# PLANNING AMENDMENT

Application No. H16/1052/94

Description: Form new sun lounge

Amendment: Amendment to apparent height of extension  
(drawing number 94/24/02B)

date OCT 94	scale(s) 1:100 1:50 1:500
job no 94/24	drg no 02 A/B

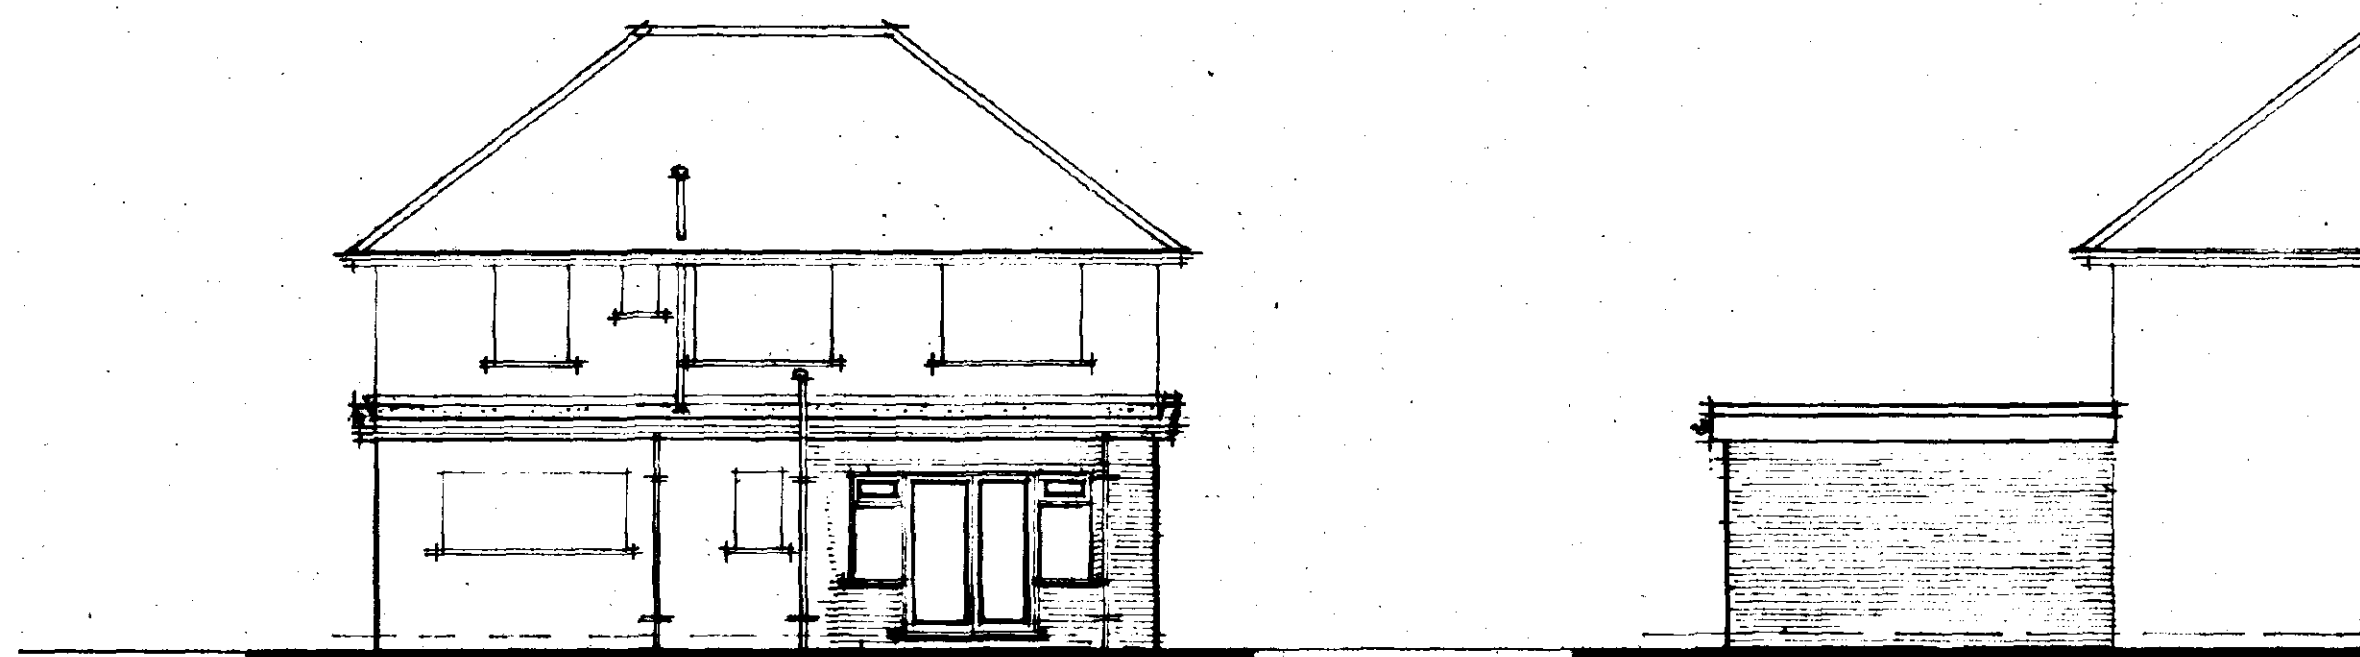
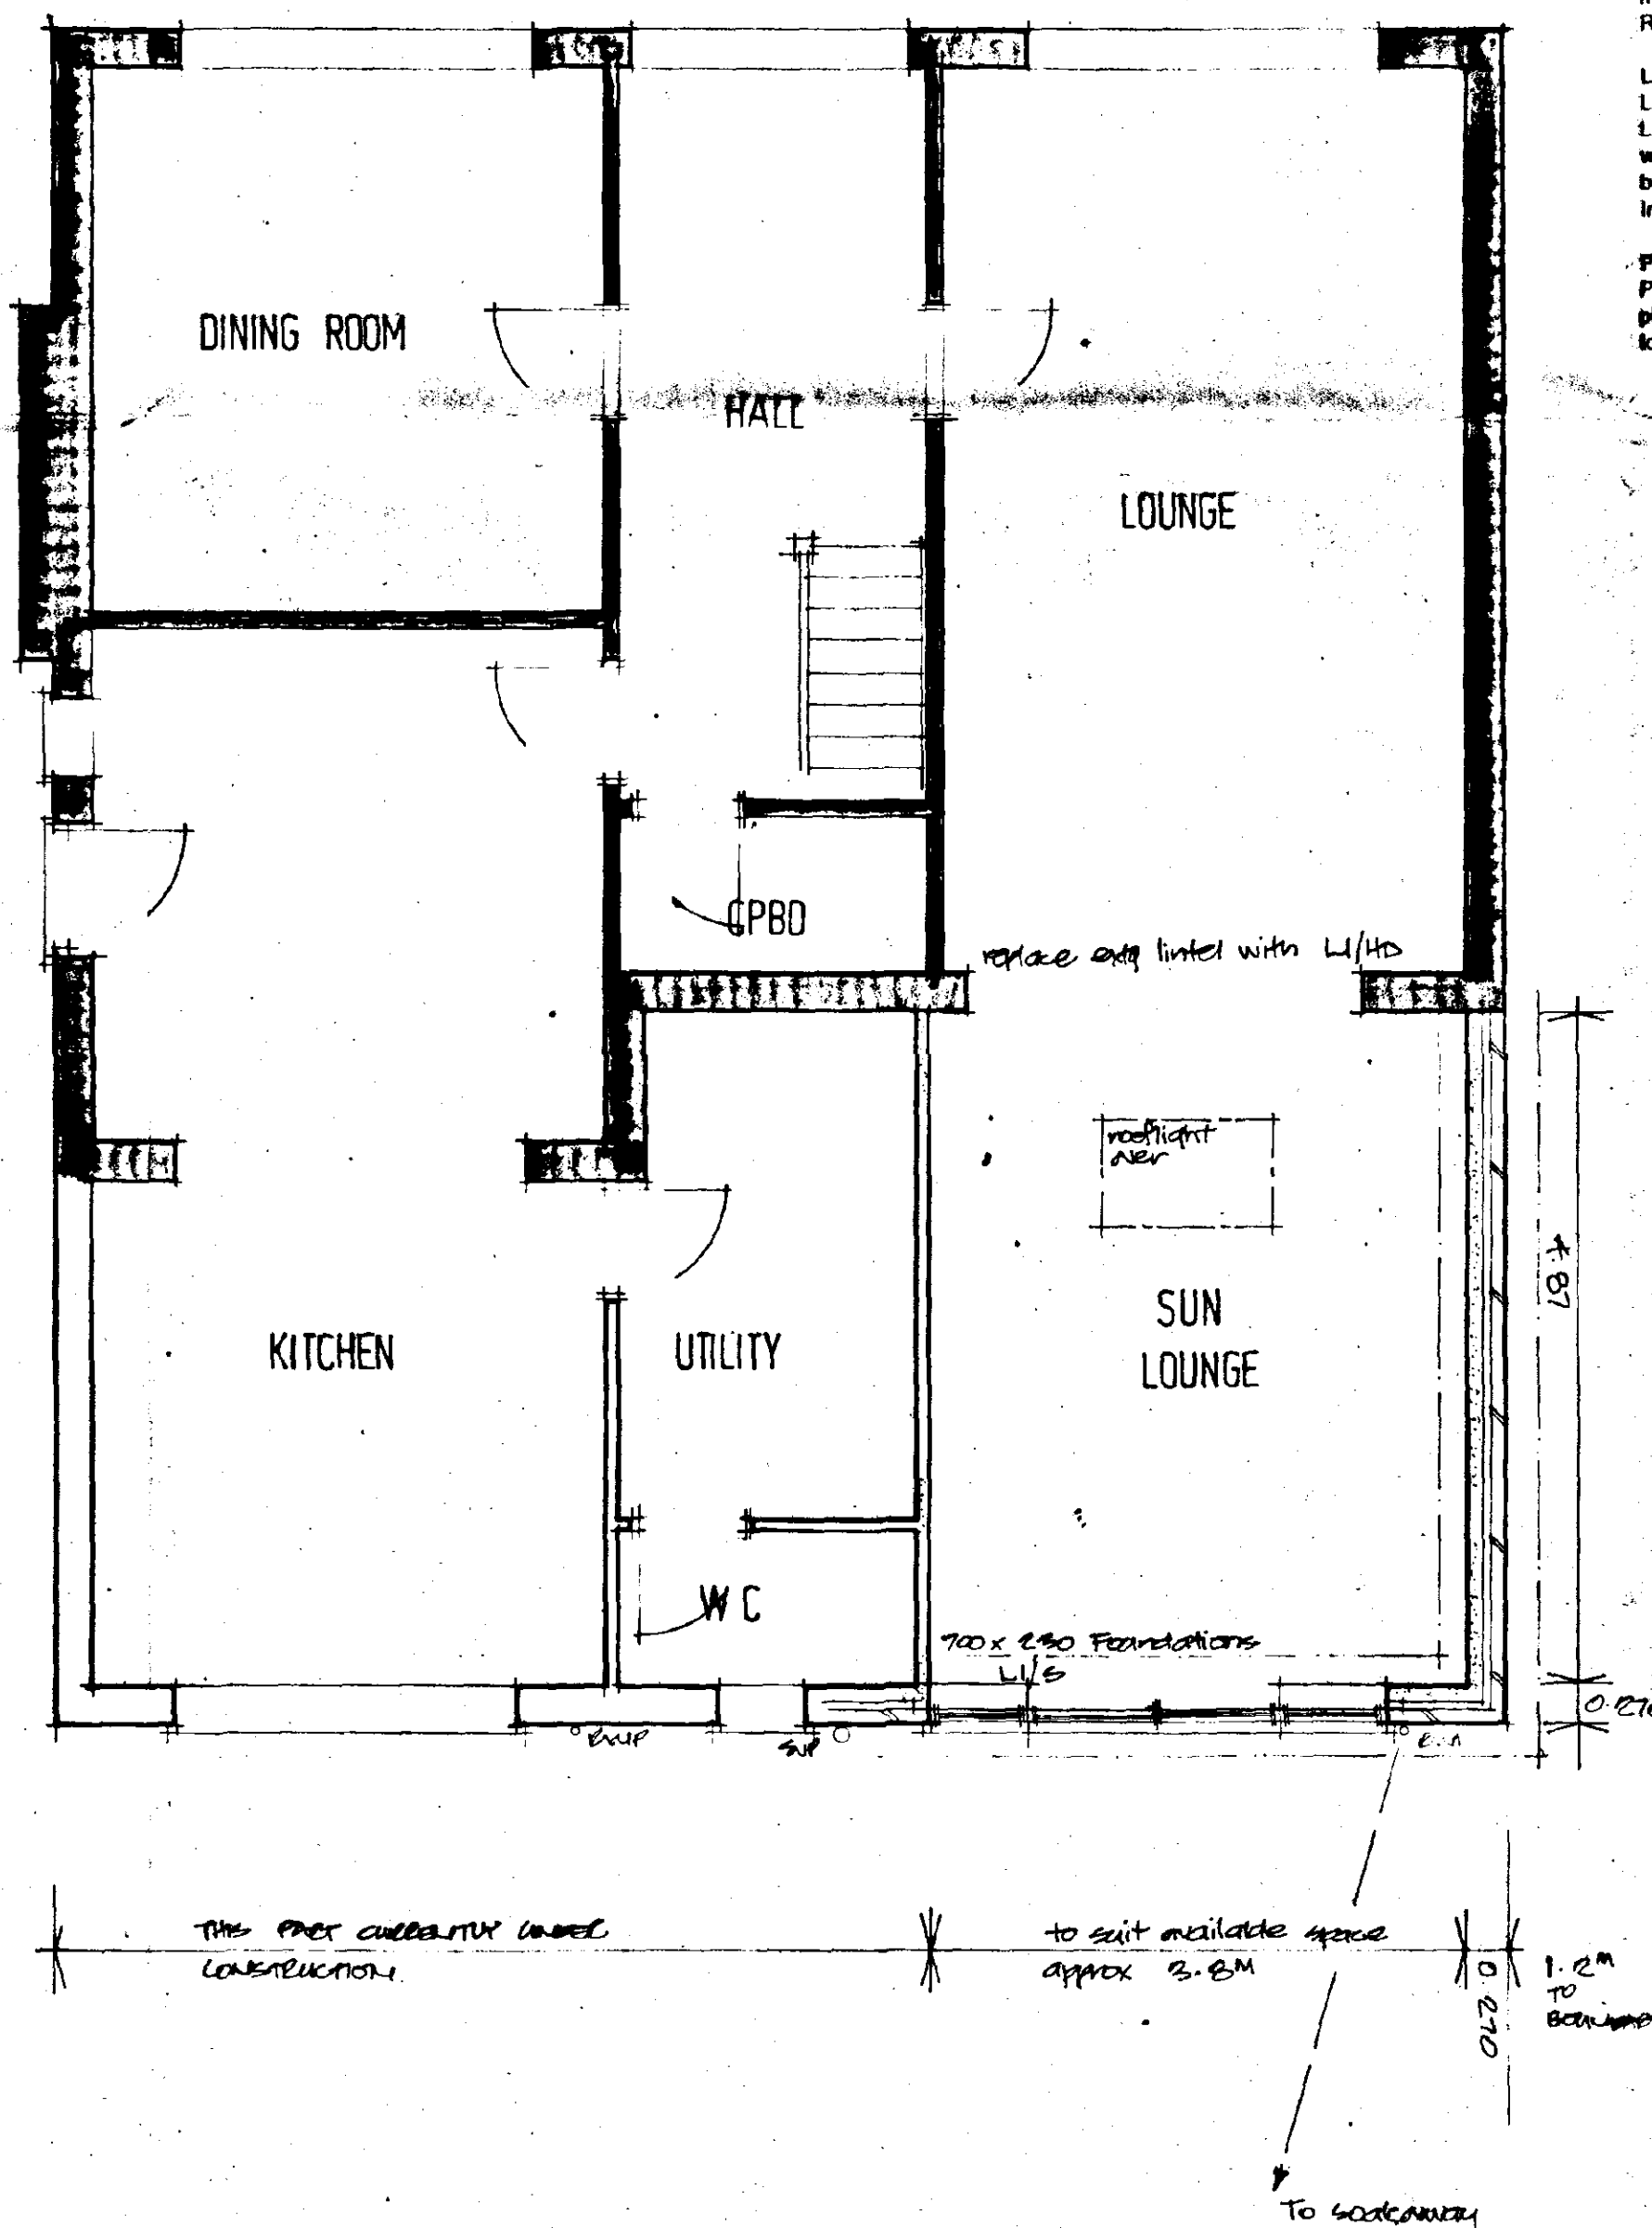
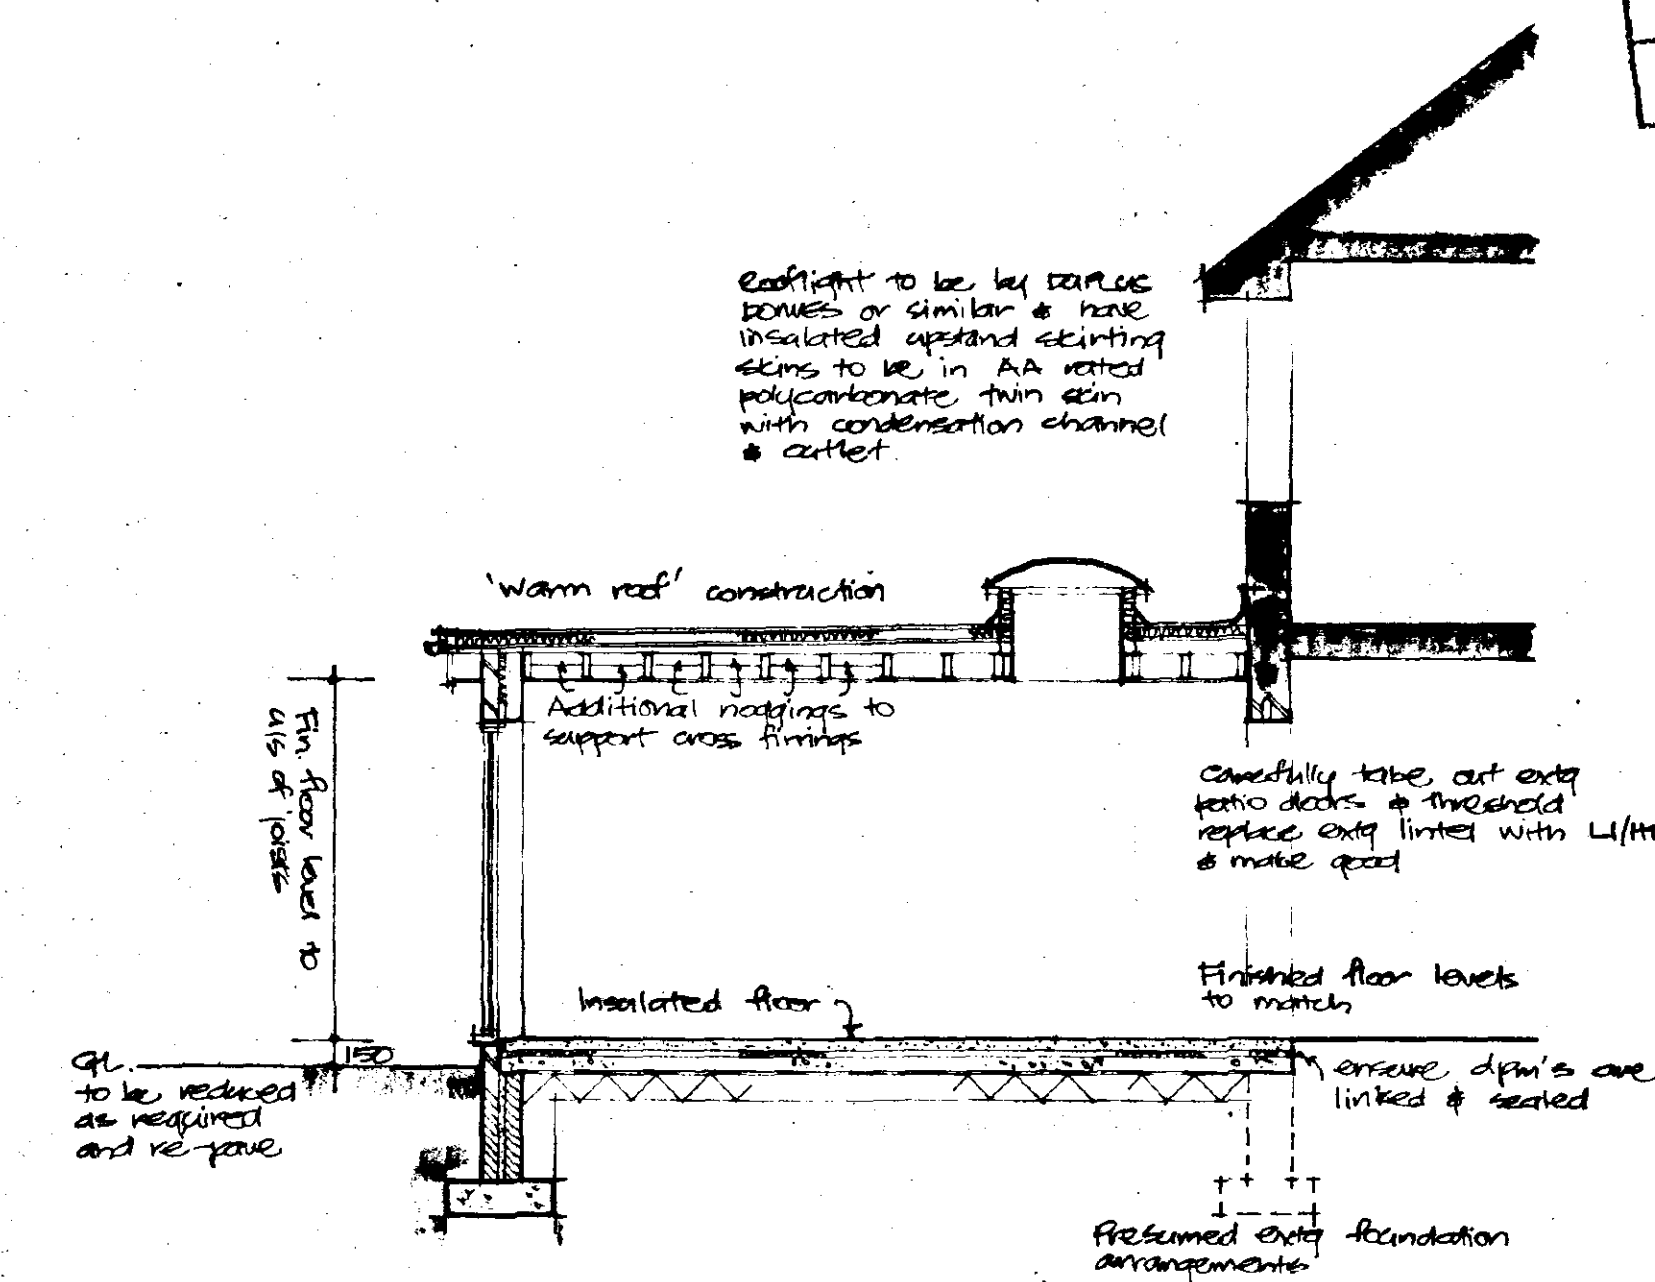
Unfortunately, it still appears that they do not accurately  
reflect the development actually built. To be more specific,  
there appears to be a greater distance between the top windows  
and the roof. This appears to be the case in respect of the  
sun lounge and also the kitchen/ utility approved earlier.

Pursuant to the above, therefore, amended plans will be  
required which rectify this in respect of the current  
application and also the previous submission (ref  
H16/051/94).

It is noted that the application is retrospective and that the development constructed does not totally accord with the submitted plans (e.g. the design of the patio doors appears to differ).
